KITTITAS COUNTY COMMUNITY DEVELOPMENT SERVICES

RE: Shoreline Exemption Permit (SX-25-00013 Schwartz) – Deemed Incomplete – Request for Additional Information

Designer: JP  
Date: 06-17-25  
**A 02**

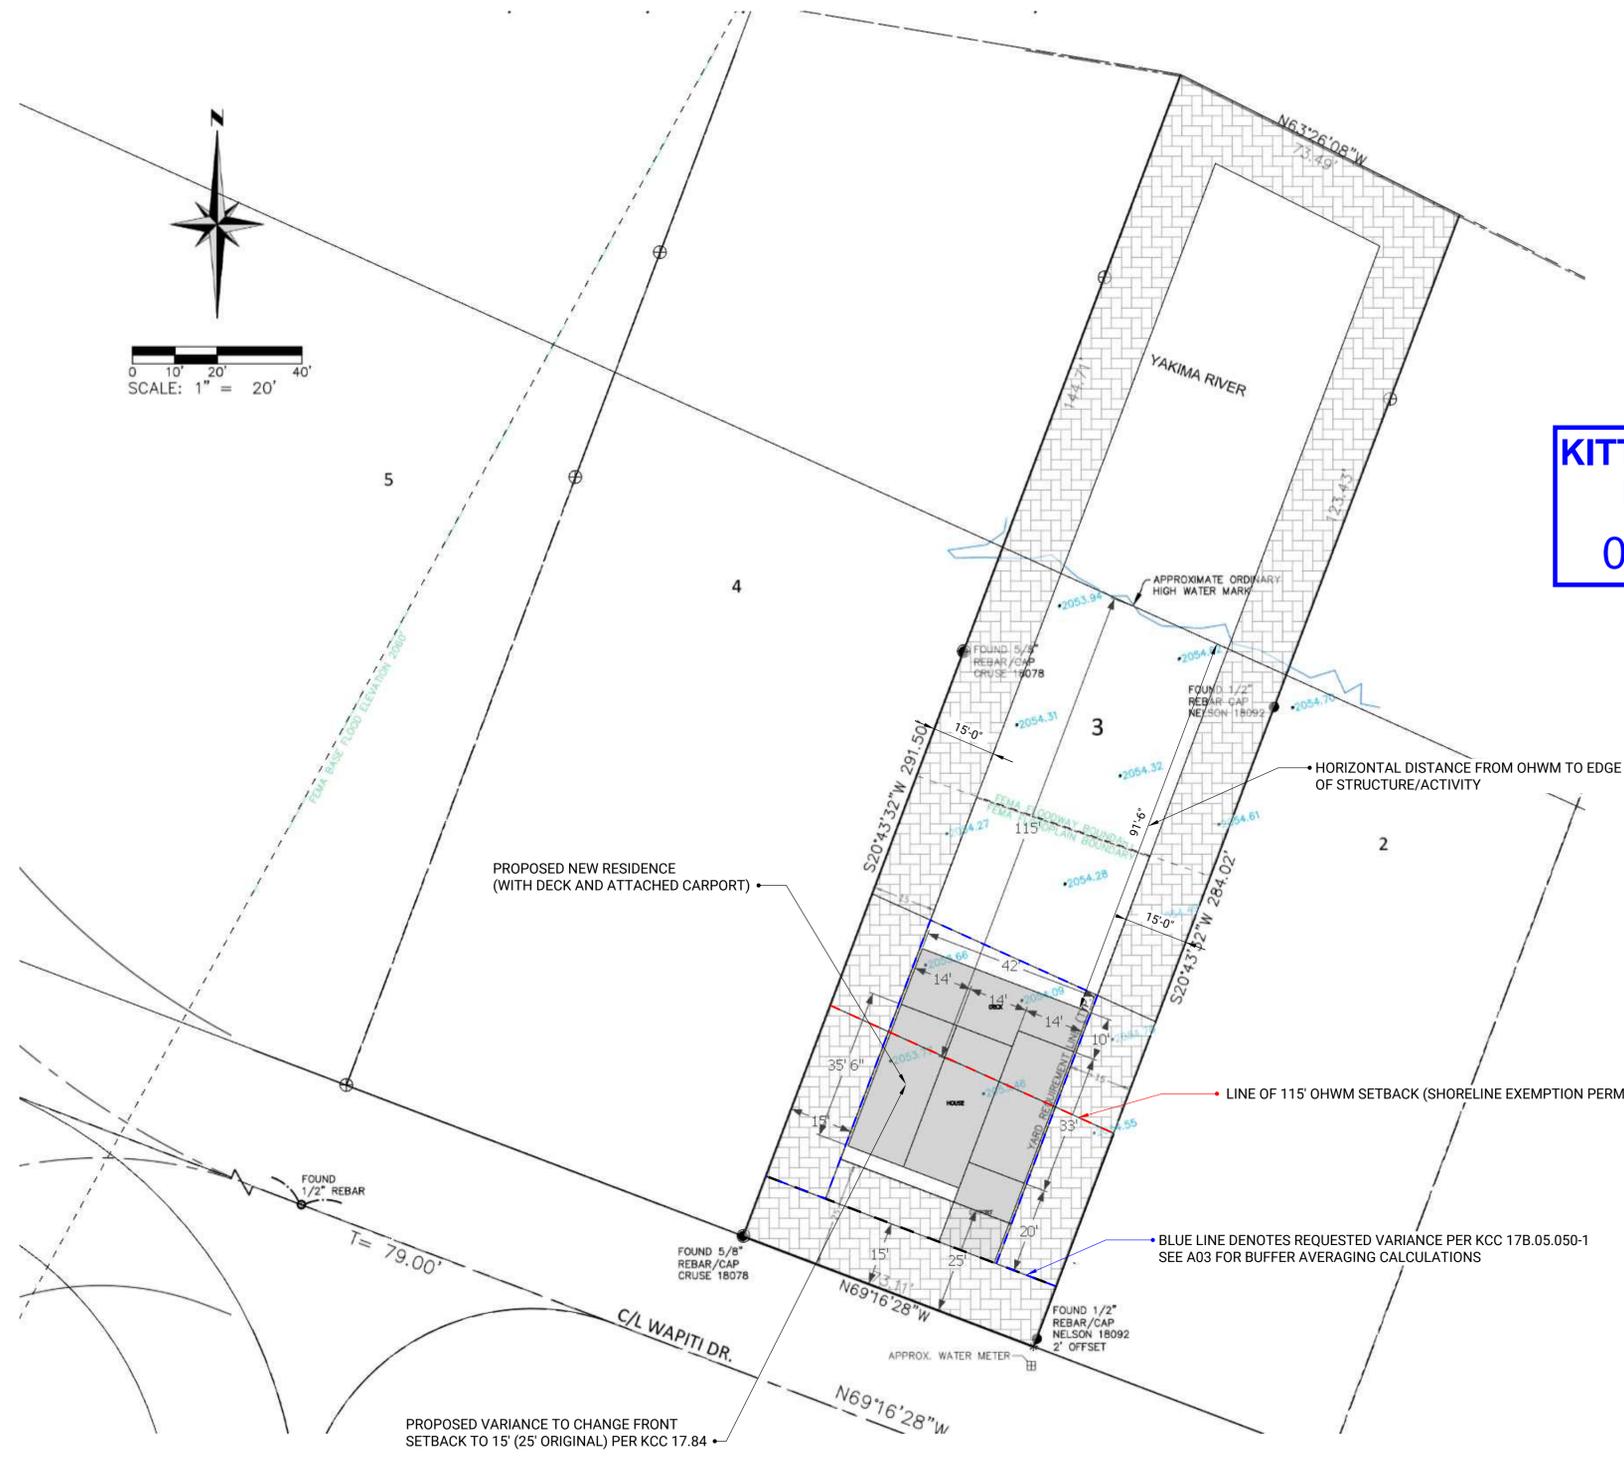
1. Please provide an updated site plan showing the exact location of all proposed structures, septic system components, drain fields, etc. In addition, please provide their dimensions, as well as each component's distances from property lines, rivers, and horizontal distances from the Ordinary High Water Mark (OHWM).
 - a. The site plan submitted with your On-Site Sewage System (OSS) application does not match the site plan provided with your shoreline exemption application. For CDS to process the shoreline exemption correctly, both applications must reference the same, consistent site plan.
